October 25, 2022

Re: Curia Building Addition
4401 Alexander Blvd NE Albuquerque, NM 87107
Grading and Drainage Plan (F16D003B1)
Letter of Response

On behalf of Curia New Mexico LLC (f/k/a Oso Biopharmaceuticals, LLC), Burns & McDonnell is pleased to submit this Letter of Response to the Grading and Drainage Plan (F16D003B1) comments received September 20, 2022. Response to comments are located below in italics and on enclosed drawings.

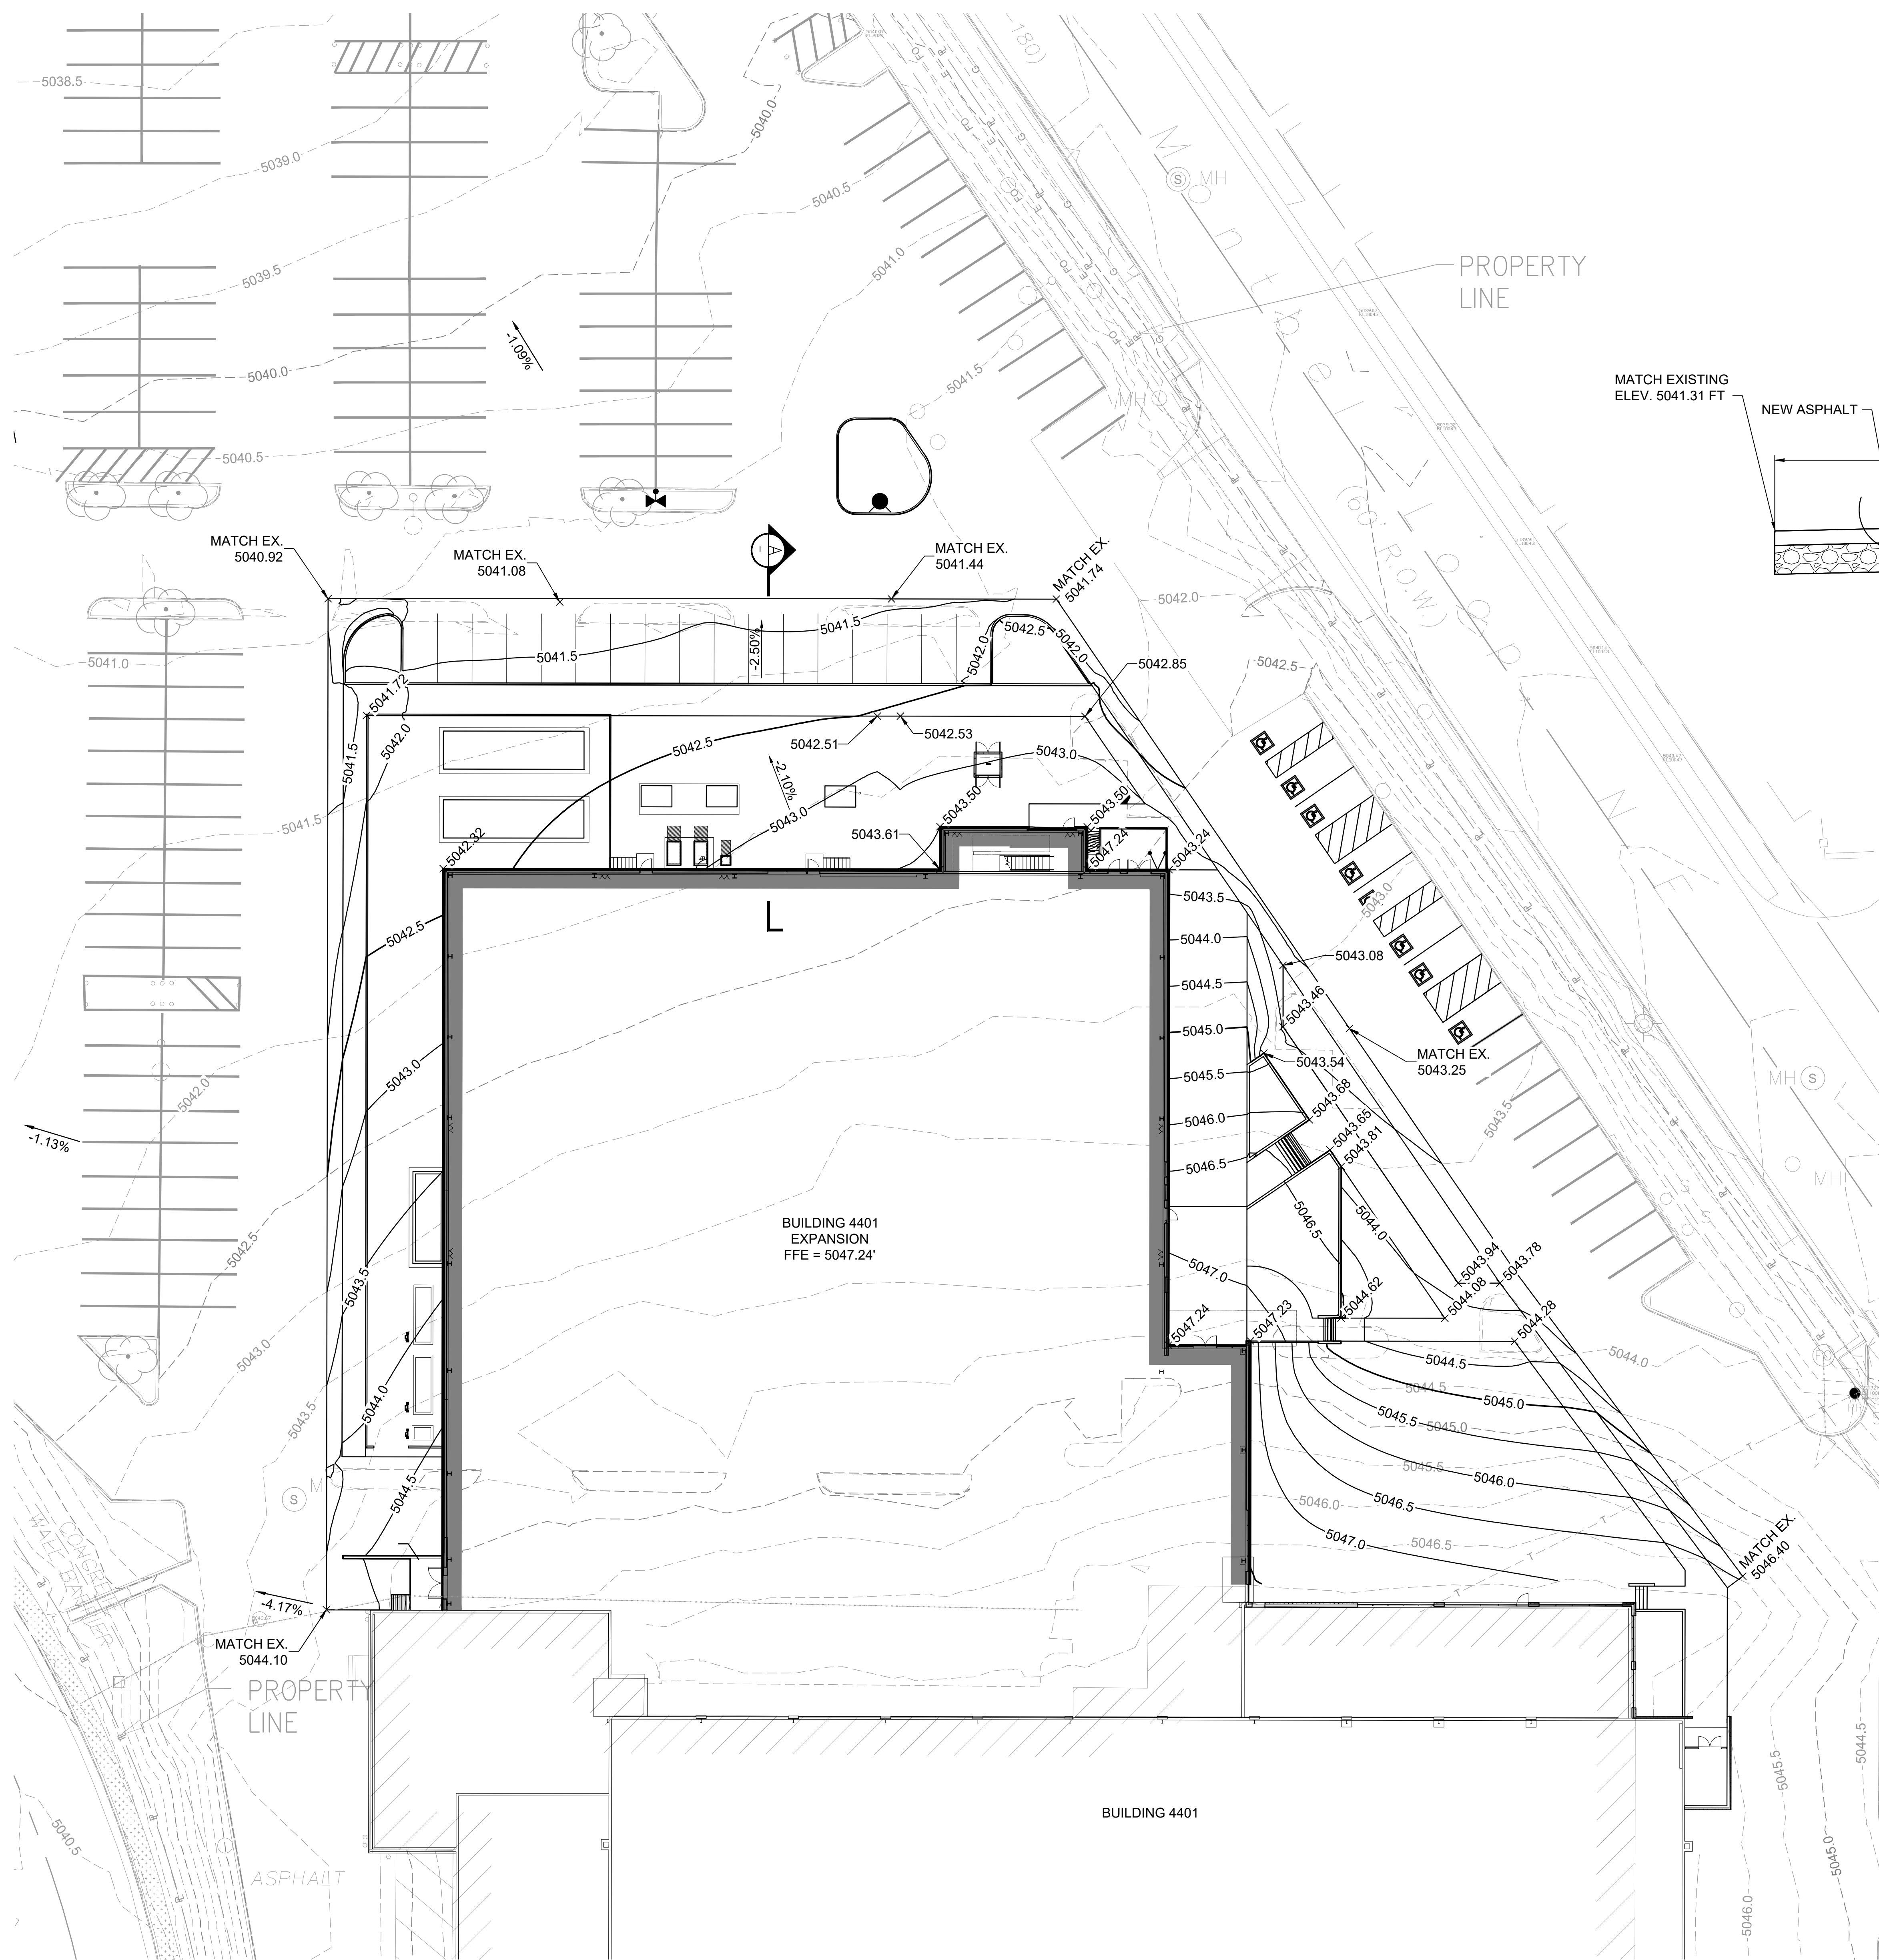
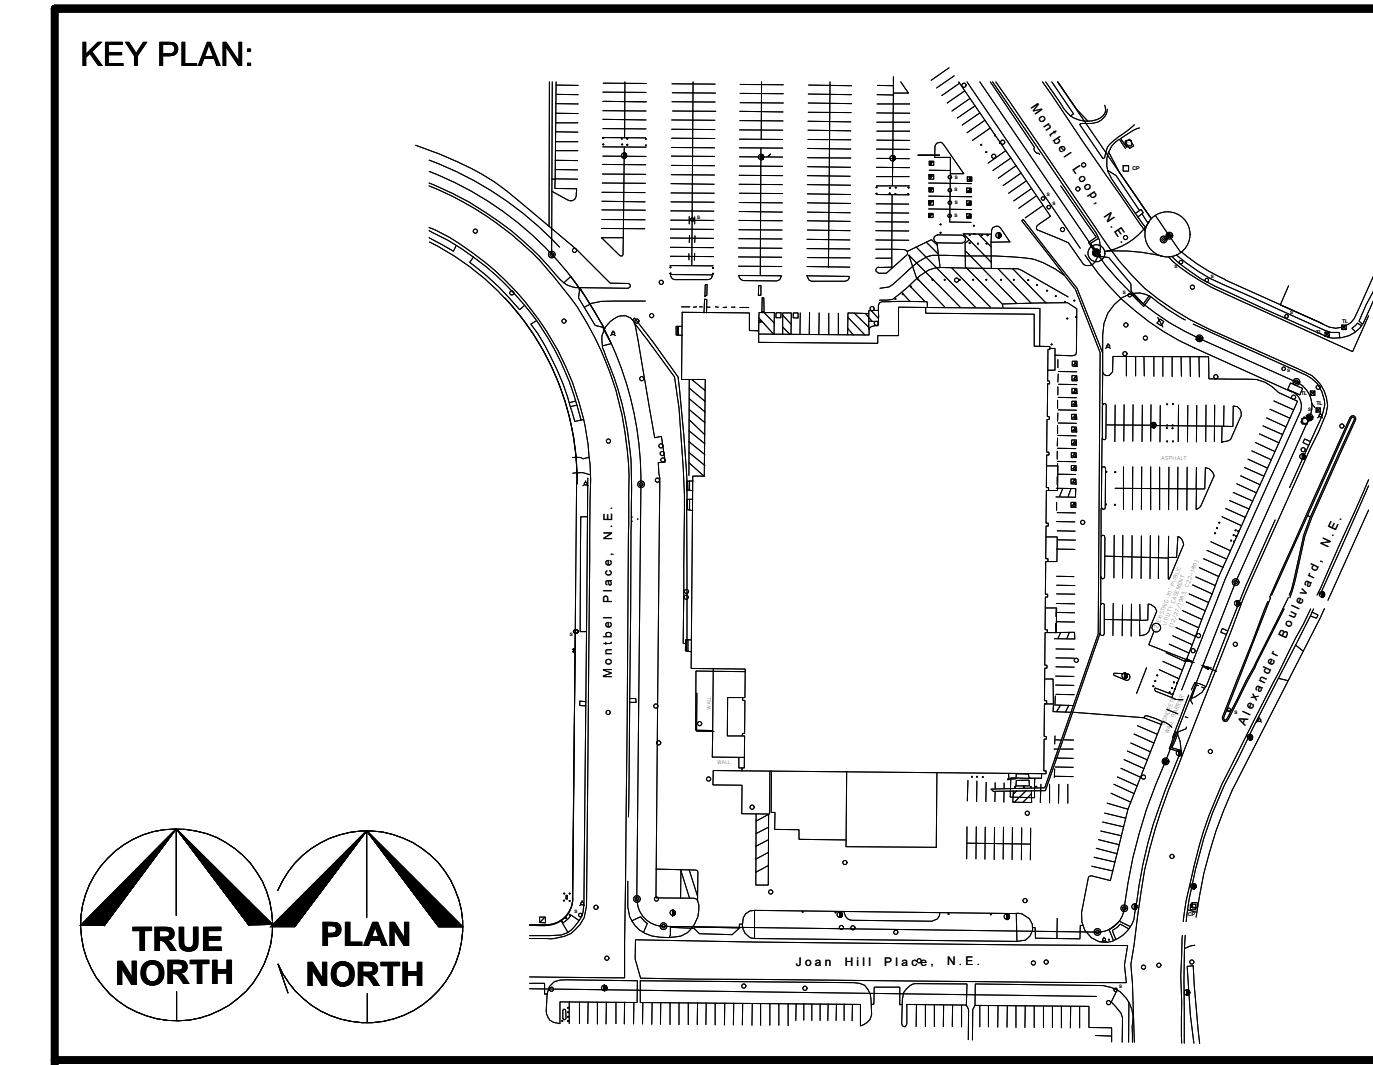
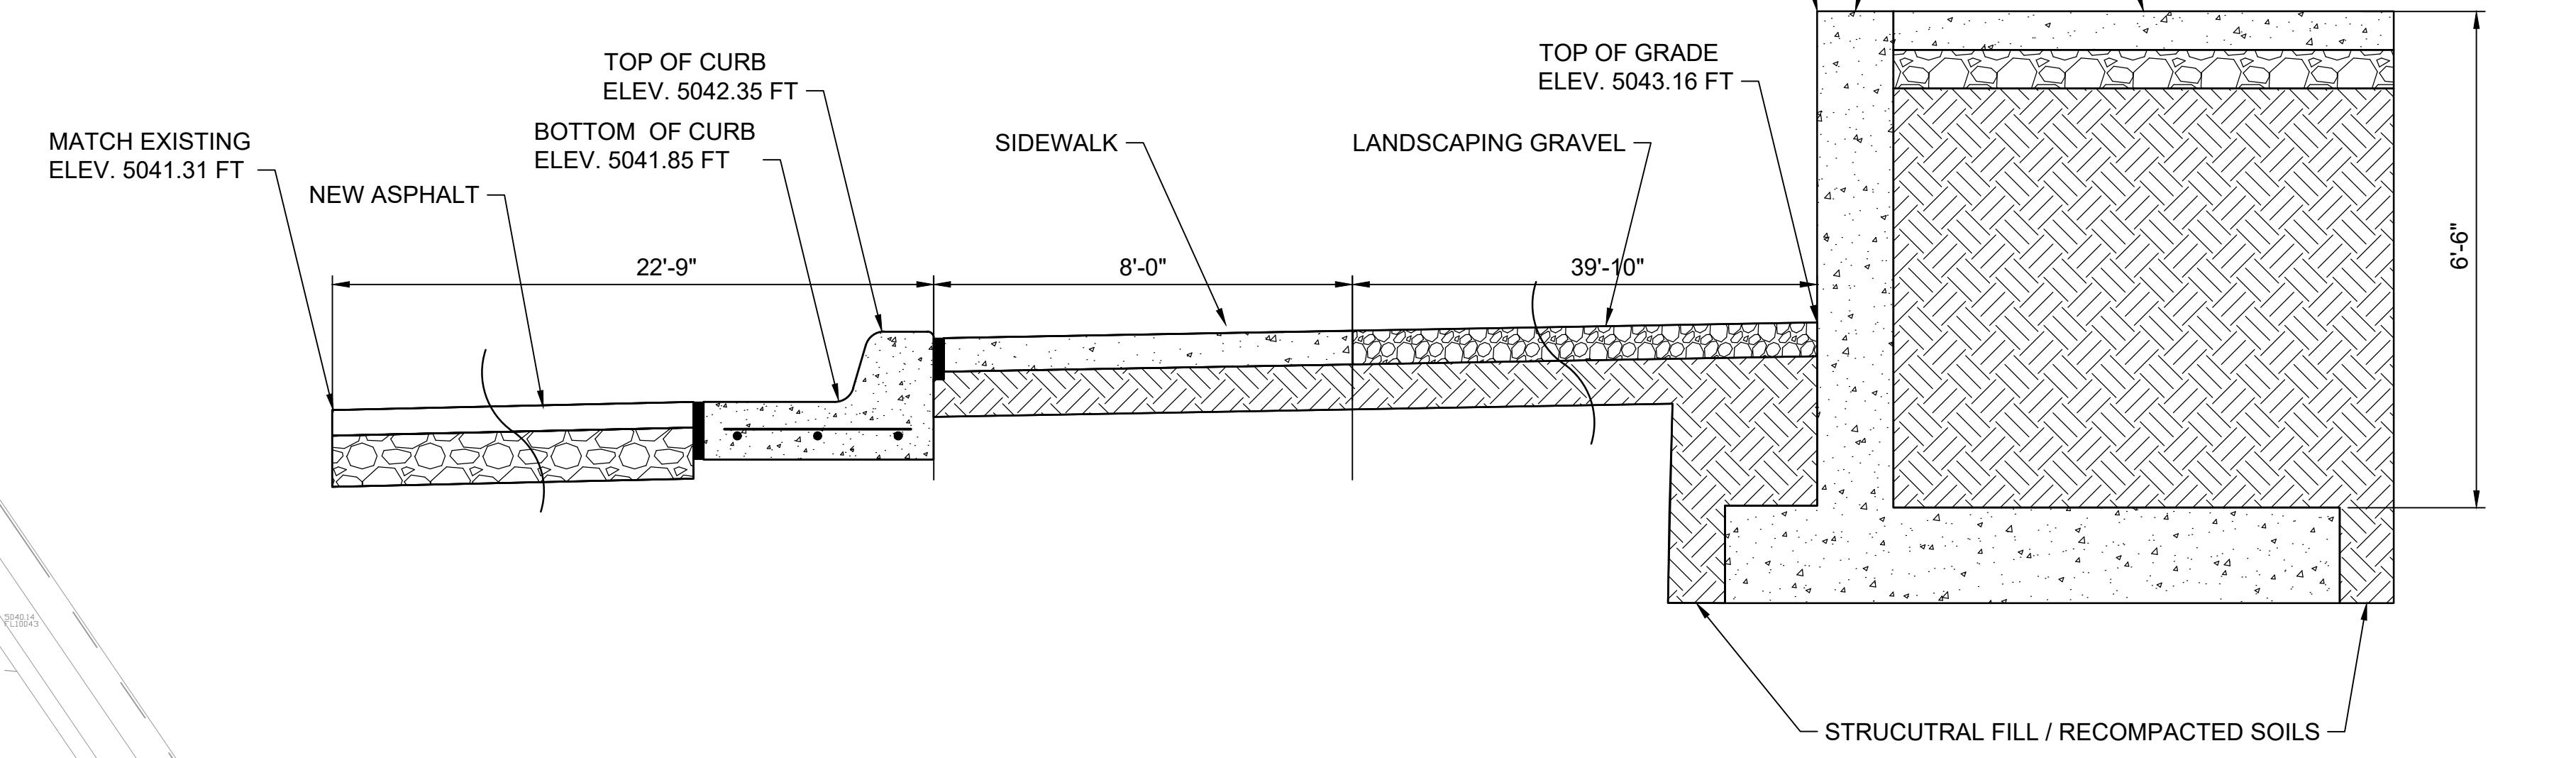
- 5) First Flush Volume requirement calculations must be provided. How will the first flush volume requirement be handled?
First Flush Volume calculations are included in CG101 Overall Grading & Drainage Plan. The existing / proposed detention pond retains the First Flush within

the volume from bottom of pipe to bottom of pond.
